Please see comments below from Private Sector Housing.

Application No: FG/149/20/PD

Site Address: 11 Sea Lane Ferring BN12 5DR

Description of Works: Prior notification under Schedule 2, Part 3, Class O of the Town & Country (General Permitted Development (England) Order (as amended) for the change of use of the existing first floor of the building from office (Class B1(a)) to 4 No. residential dwellings (Use Class C3) .

ROOF PLAN 1:200

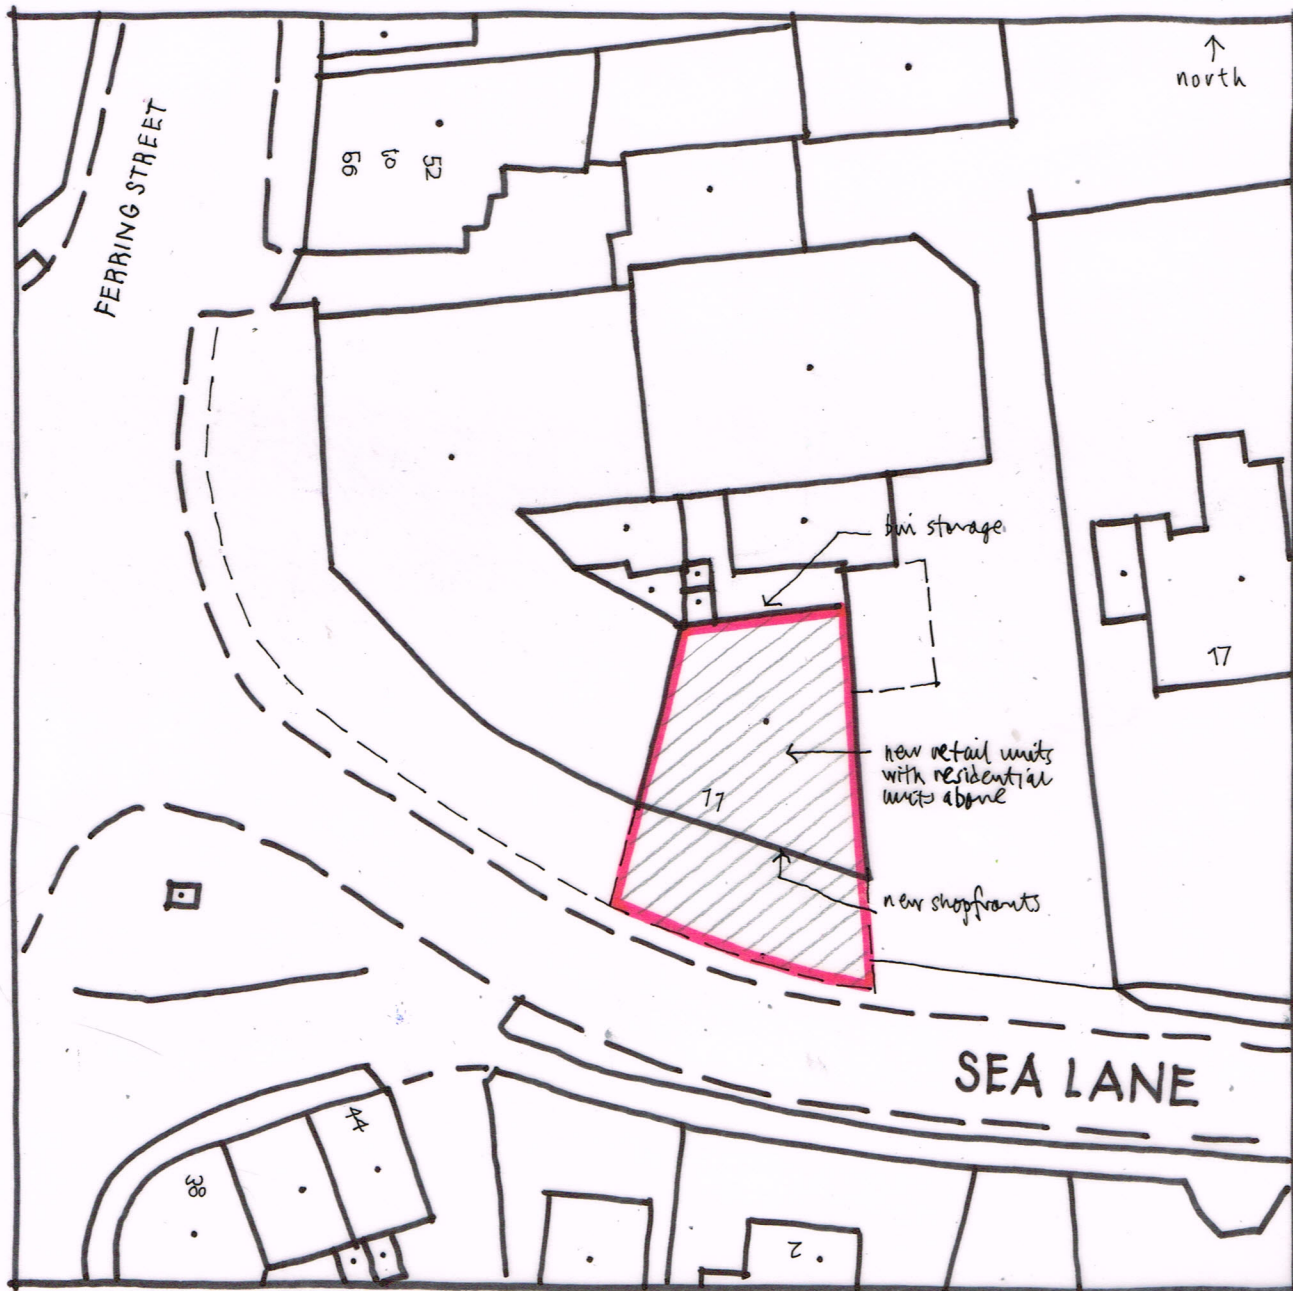
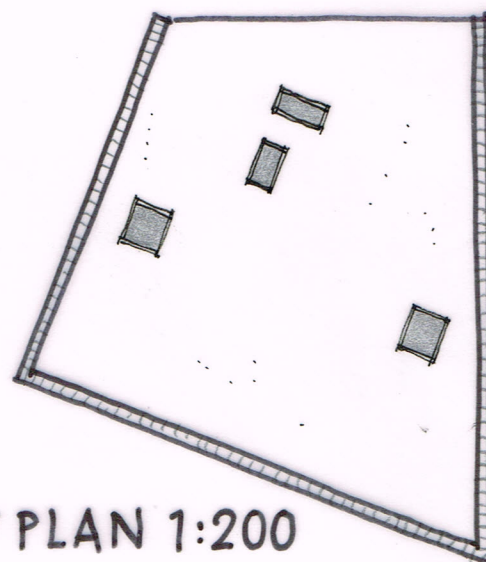
- Opening limiters should be installed to all windows above the ground floor to prevent windows being opened more than 100mm. Opening limiters should not be key operated
- The roof window serving Flat 1 should be of an appropriate height and angle to provide a 'reasonable view'

Drawing no. FG/SL/04

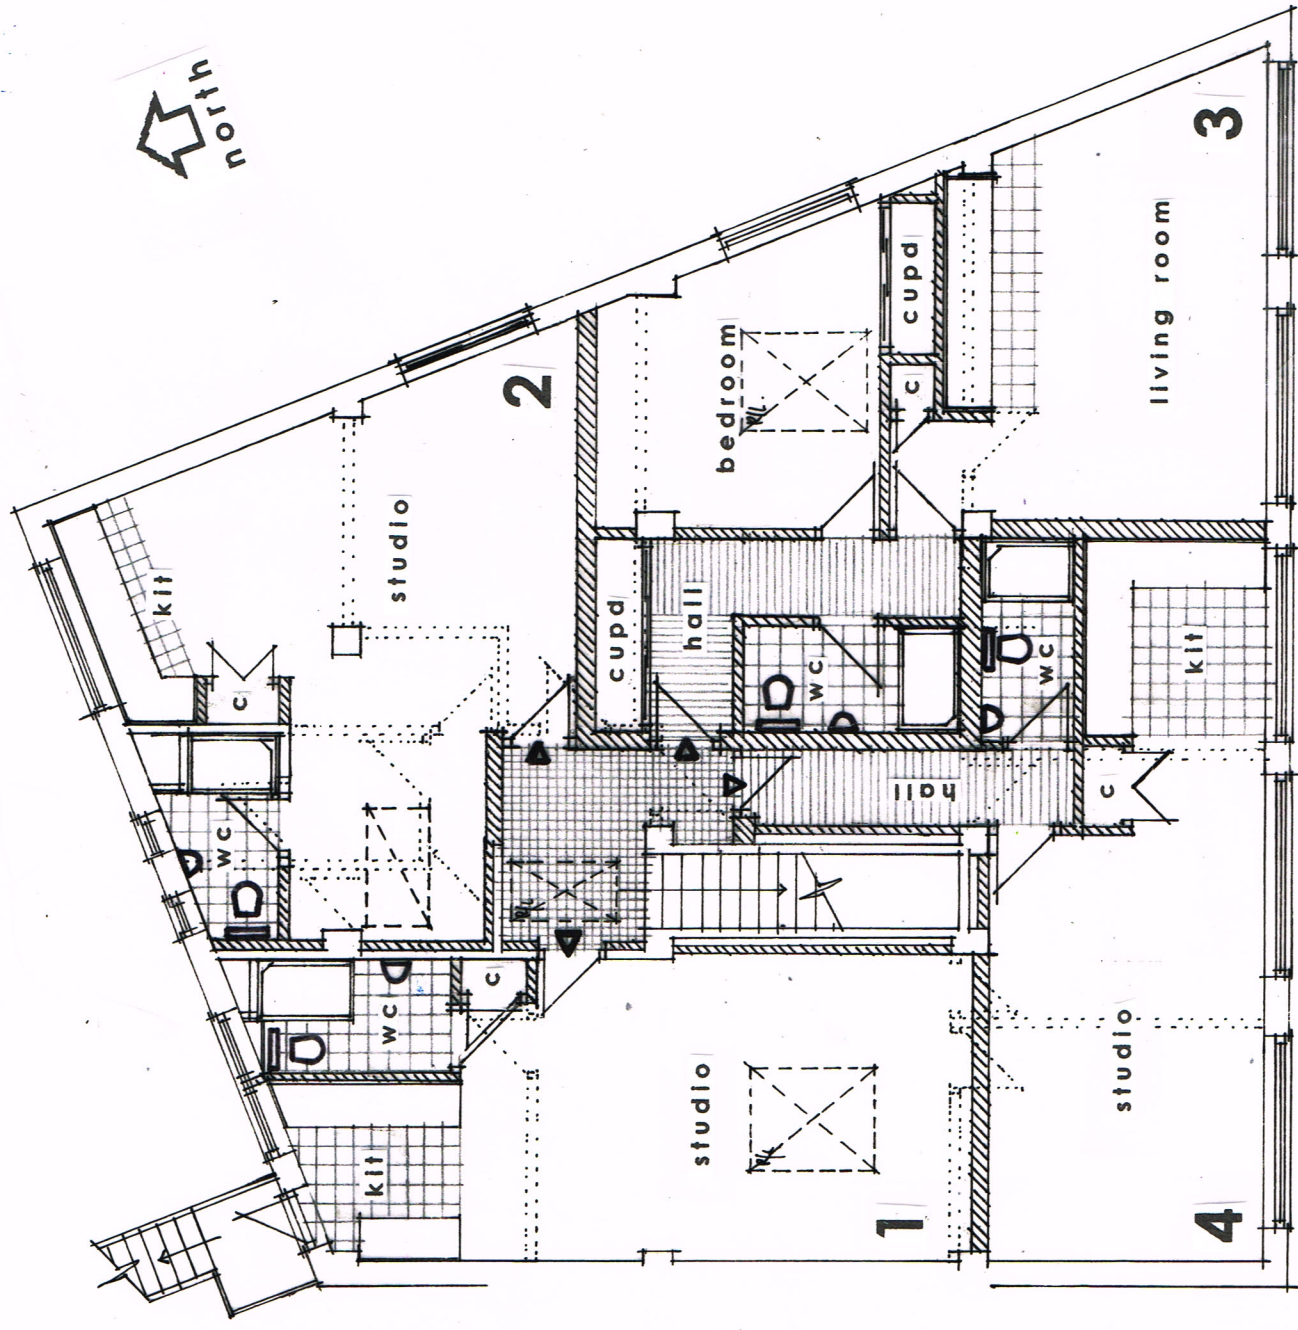
- Appropriate fire precaution facilities and equipment must be provided of such type, number and location as are considered necessary. Guidance on fire safety is contained in the LACORS guidance document – “Housing – Fire Safety, Guidance on fire safety precautions for certain types of existing housing”
- There should be adequate fire separation (usually 60 minutes) between the commercial units on the ground floor and the residential flats above

- The internal escape route should provide 30 minutes fire resistance, including the provision of 30-minute fire resisting and self-closing fire doors (FD30S) to each flat entrance
- A mixed Grade D1, LD2 and Grade D1, LD3 fire alarm system should be maintained and installed

- Fire blankets should be provided to all kitchen areas
- The bedroom within Flat 3 backs onto the kitchen area; the compartmentation between these rooms must afford 30 minutes fire resistance
